Markup Summary

FIGURE 5

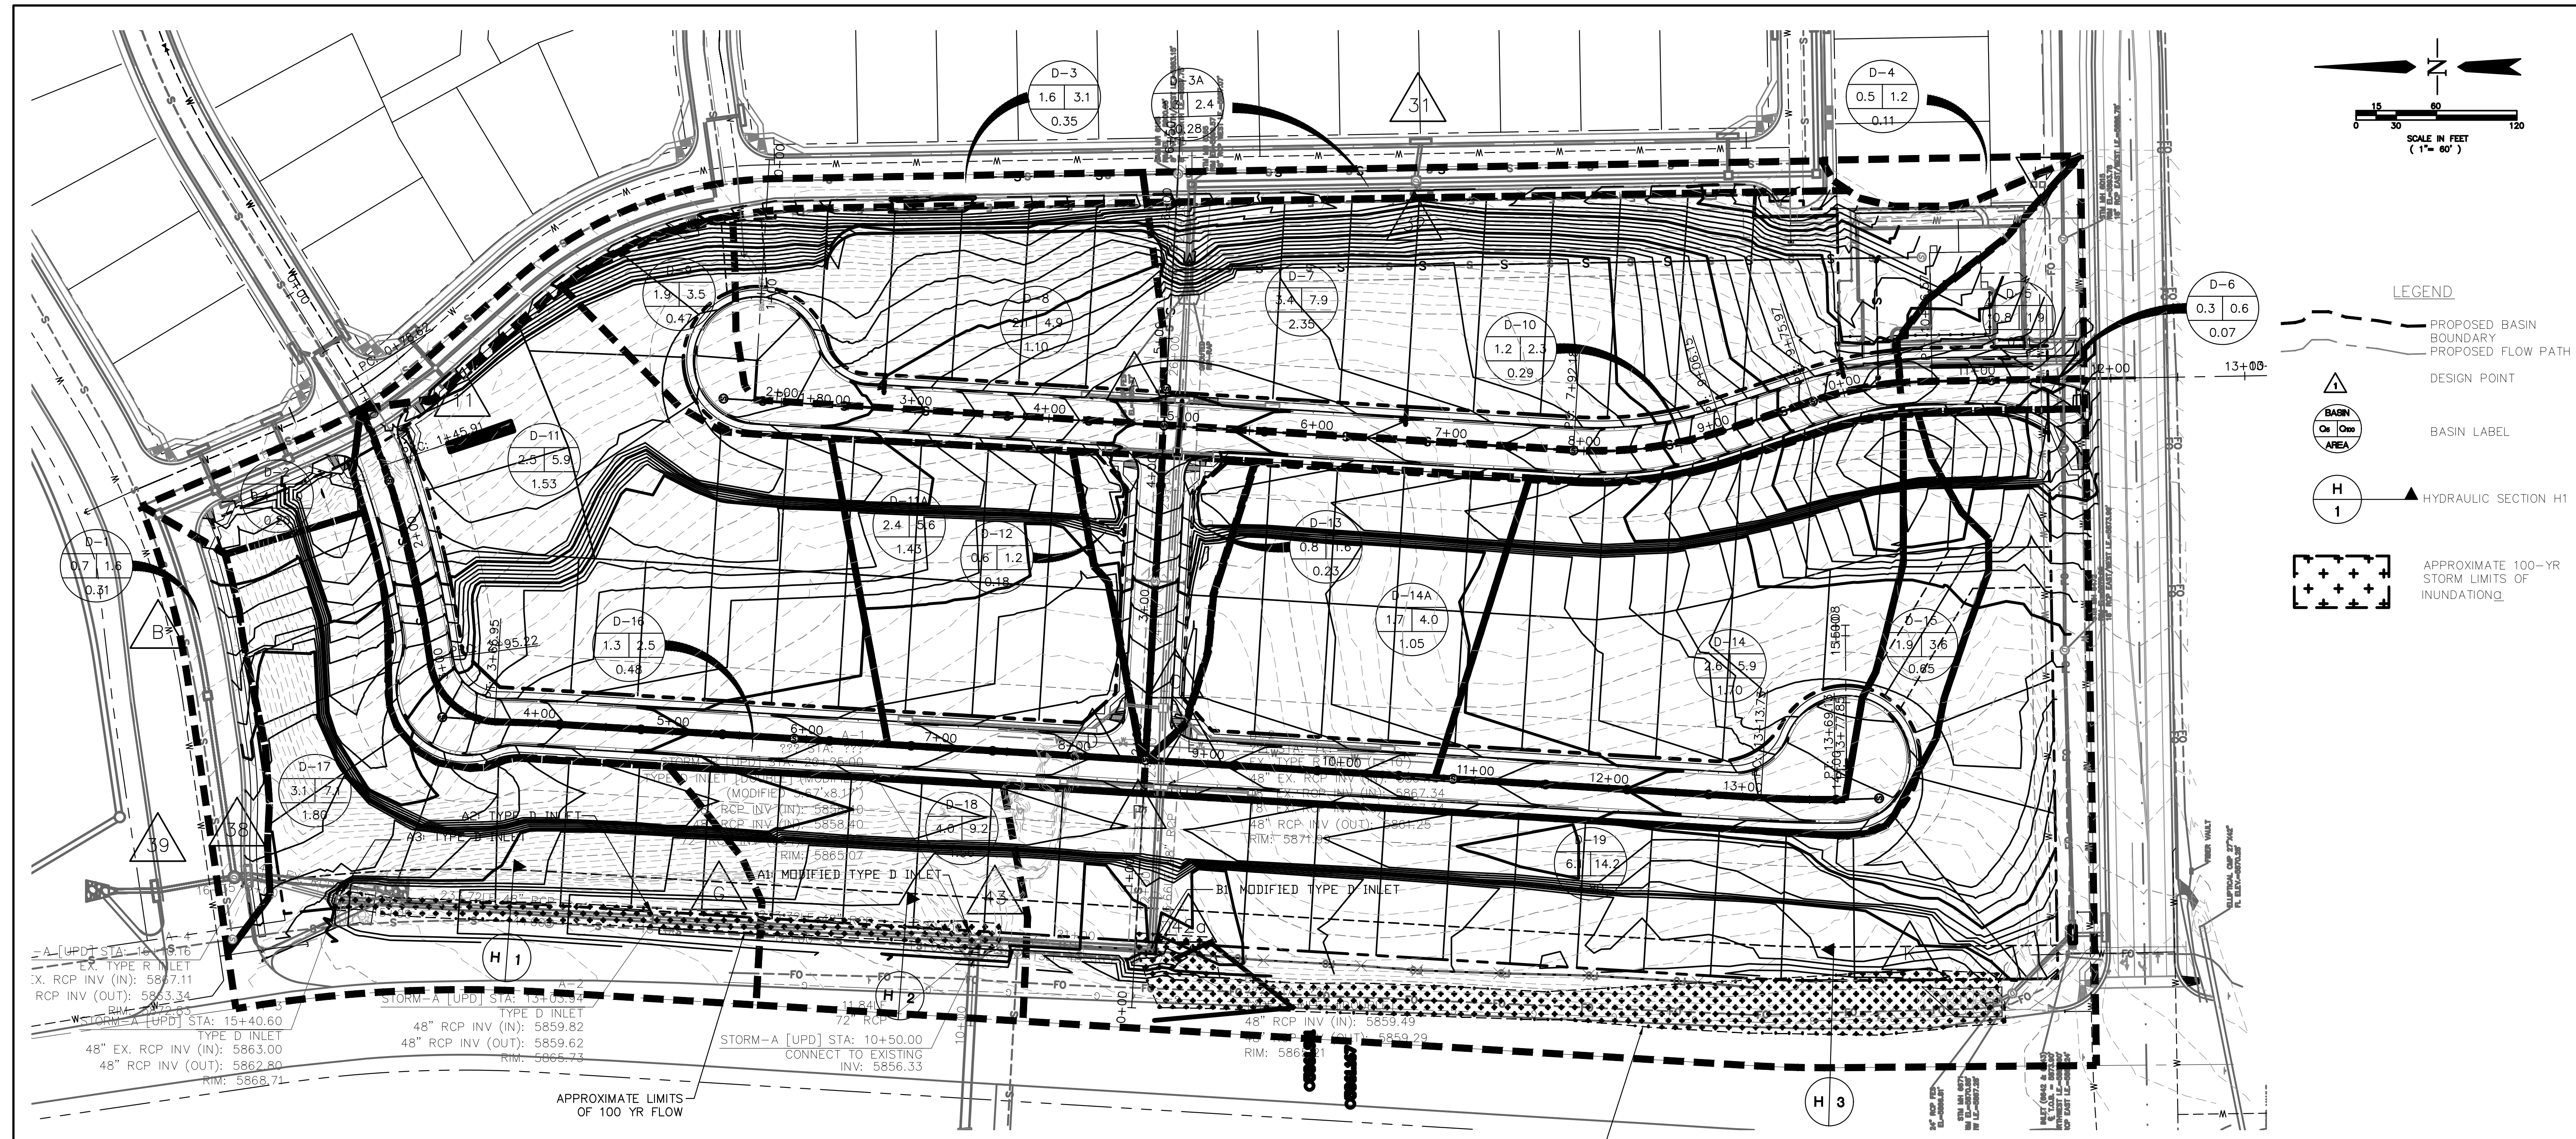
Delineate the spread of the 100yr runoff. Unresolved.
Review 2: Show this on both sides for the full length along Grinnell Blvd. Depending on extent, additional drainage easements and/or improvements may be required.

Update the narrative for DP-K (pg 10) by elaborating on the findings/recommendations regarding this swale. Per ECM Section 3.3.4 the minimum freeboard shall be 0.5 foot. Based on the 100yr spread shown, the existing swale has insufficient capacity. Revise the design accordingly and update the DP 42a channel analysis accordingly.

Extent of 100-year flooding
is shown and remains in the
Grinnell Boulevard r.o.w.
Narrative revised to
describe. Design carries
flow.
